DEVELOPMENT MANAGEMENT ADVICE

Your Ref: DC/2024/01754
File Ref: SF24-061
W/P Ref: e_DM folder
Date: 14 October 2024

Mersey Tidal Power Project, River Mersey, Liverpool, Neighbouring Authority Consultation regarding Environmental Statement (ES) and the scoping opinion for the proposed Mersey Tidal Power Project Scoping Consultation

Mersey Tidal Power Scoping Report
 Chapter 13: Terrestrial Ecology and Biodiversity
Figure 13.4 Statutory Designated Biodiversity Sites of Local Importance

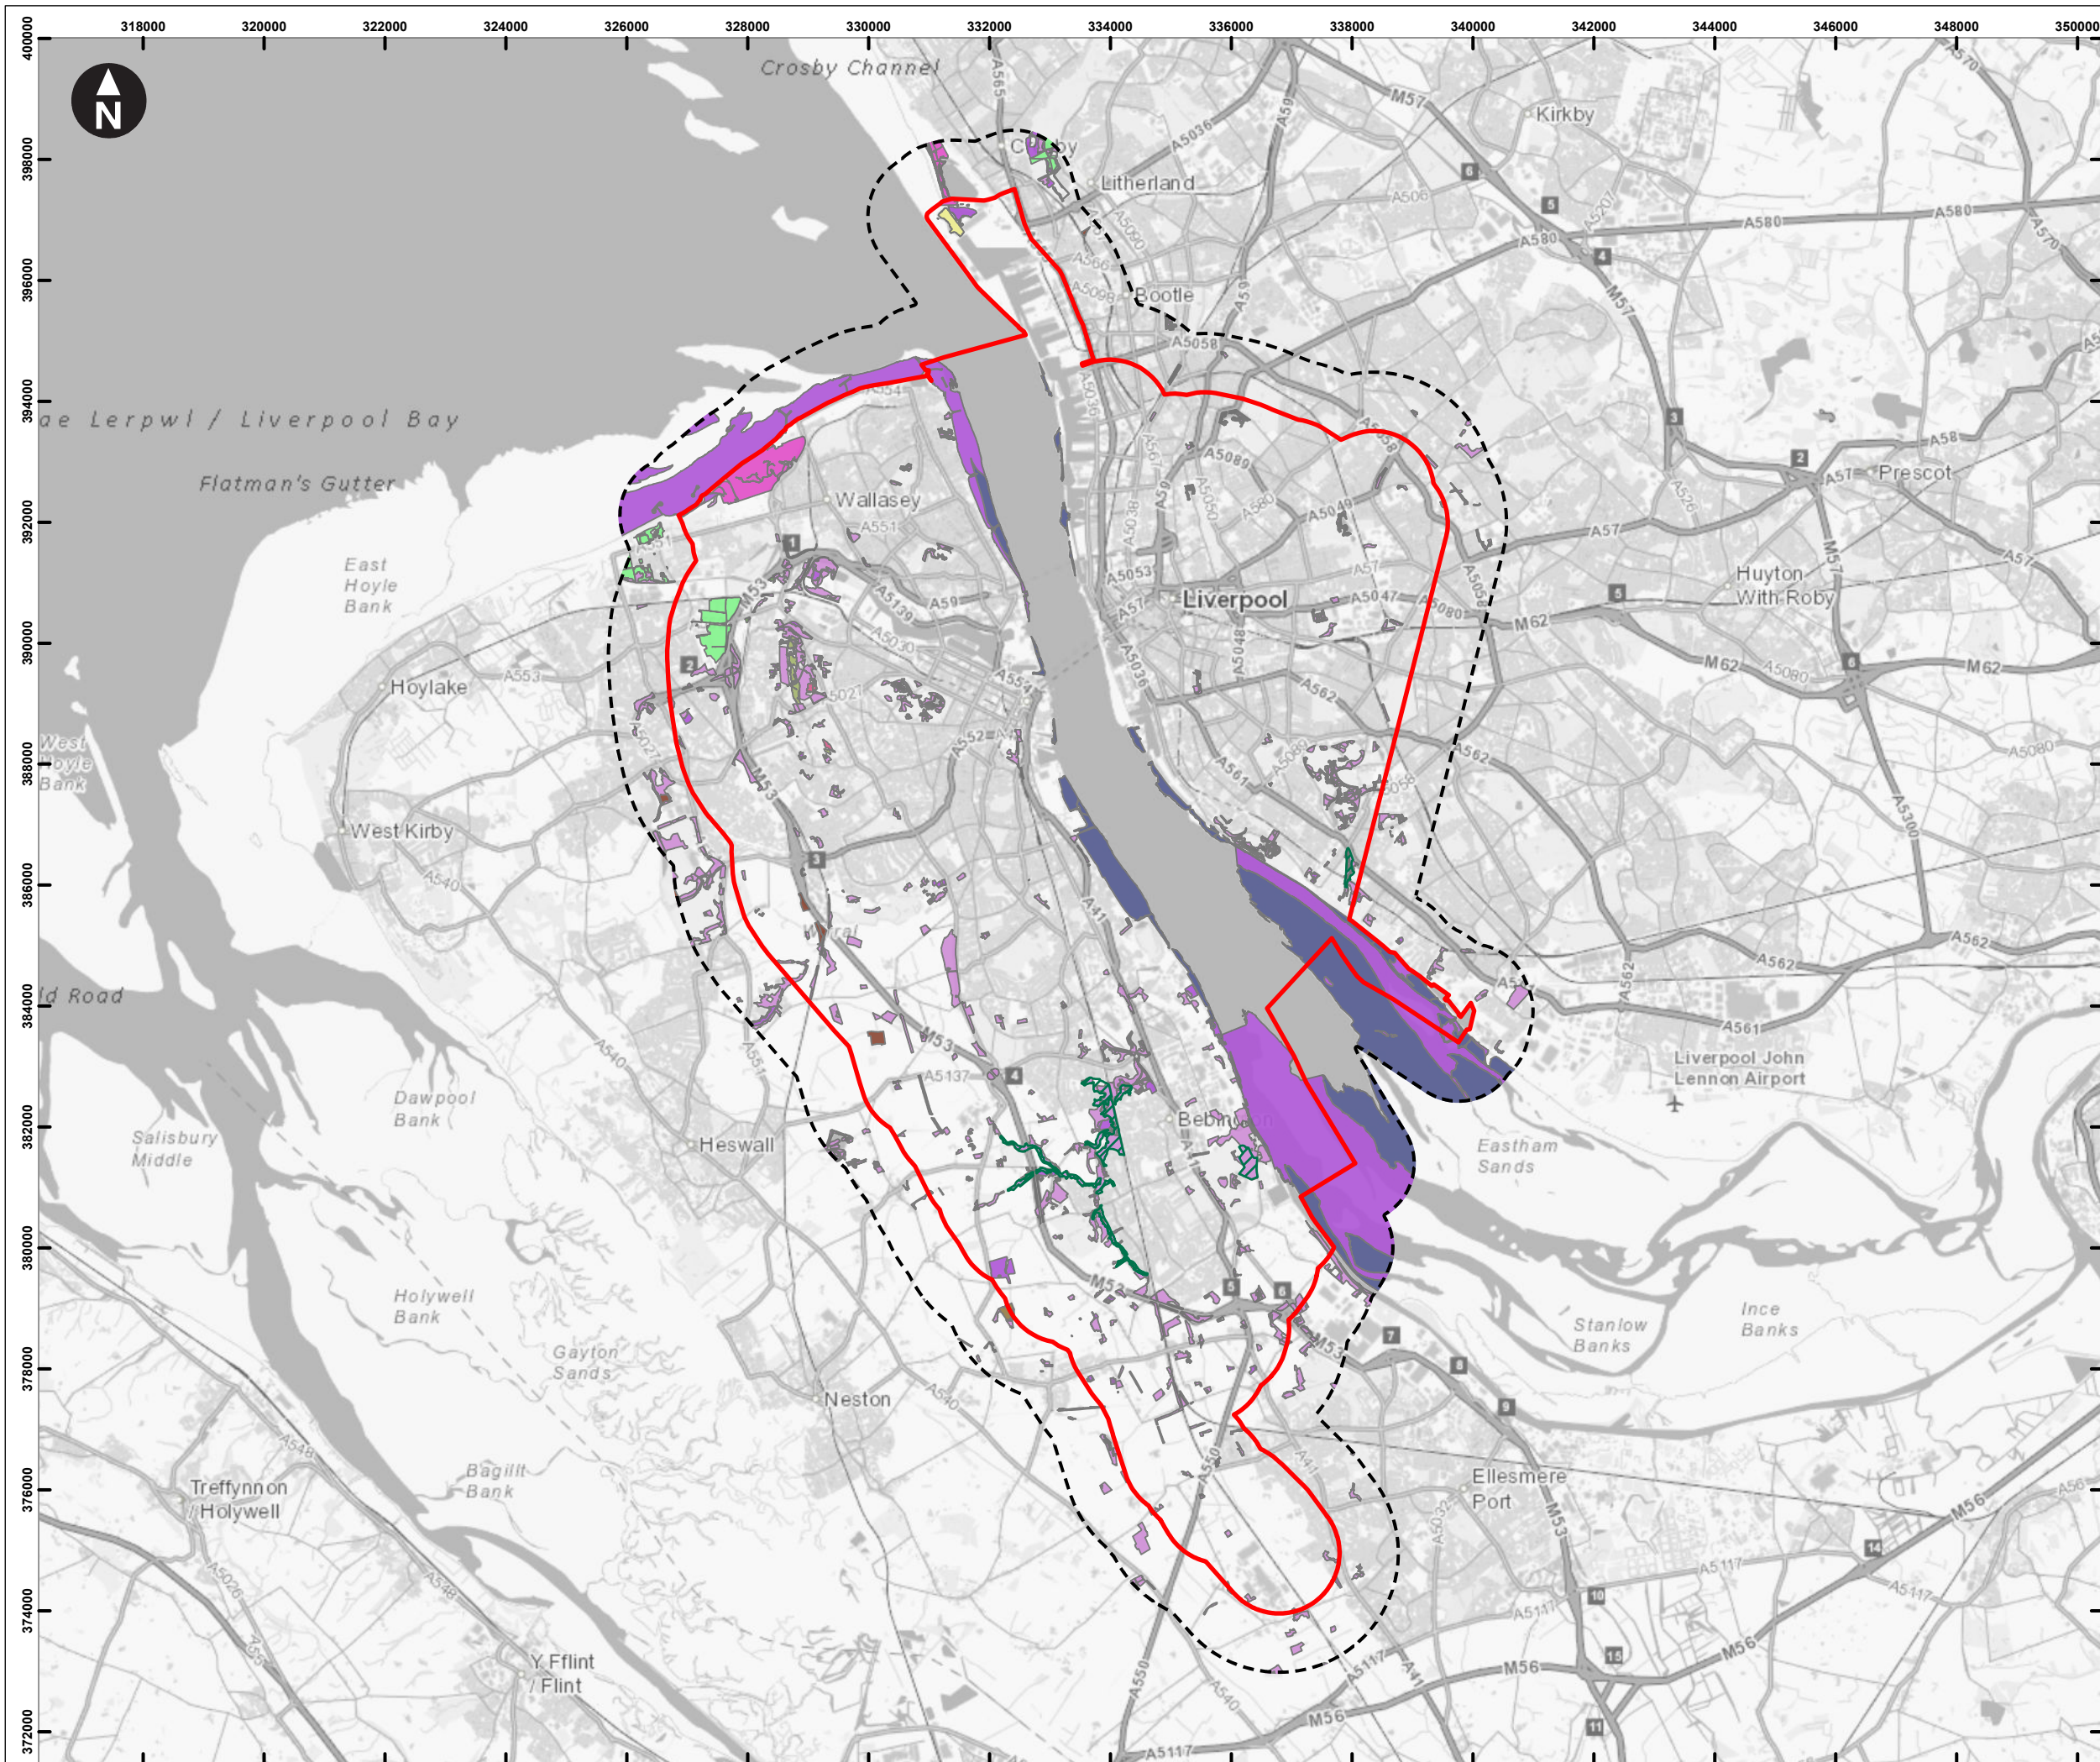
16. It is noted that no Local Records Centre Record data search was carried out for species records within the scoping area or for non-statutory designated sites. Local Wildlife Sites (LWS) have not been included in this scoping EIA chapter and so have not been assessed. Also, there is no figure showing the locations of these sites.
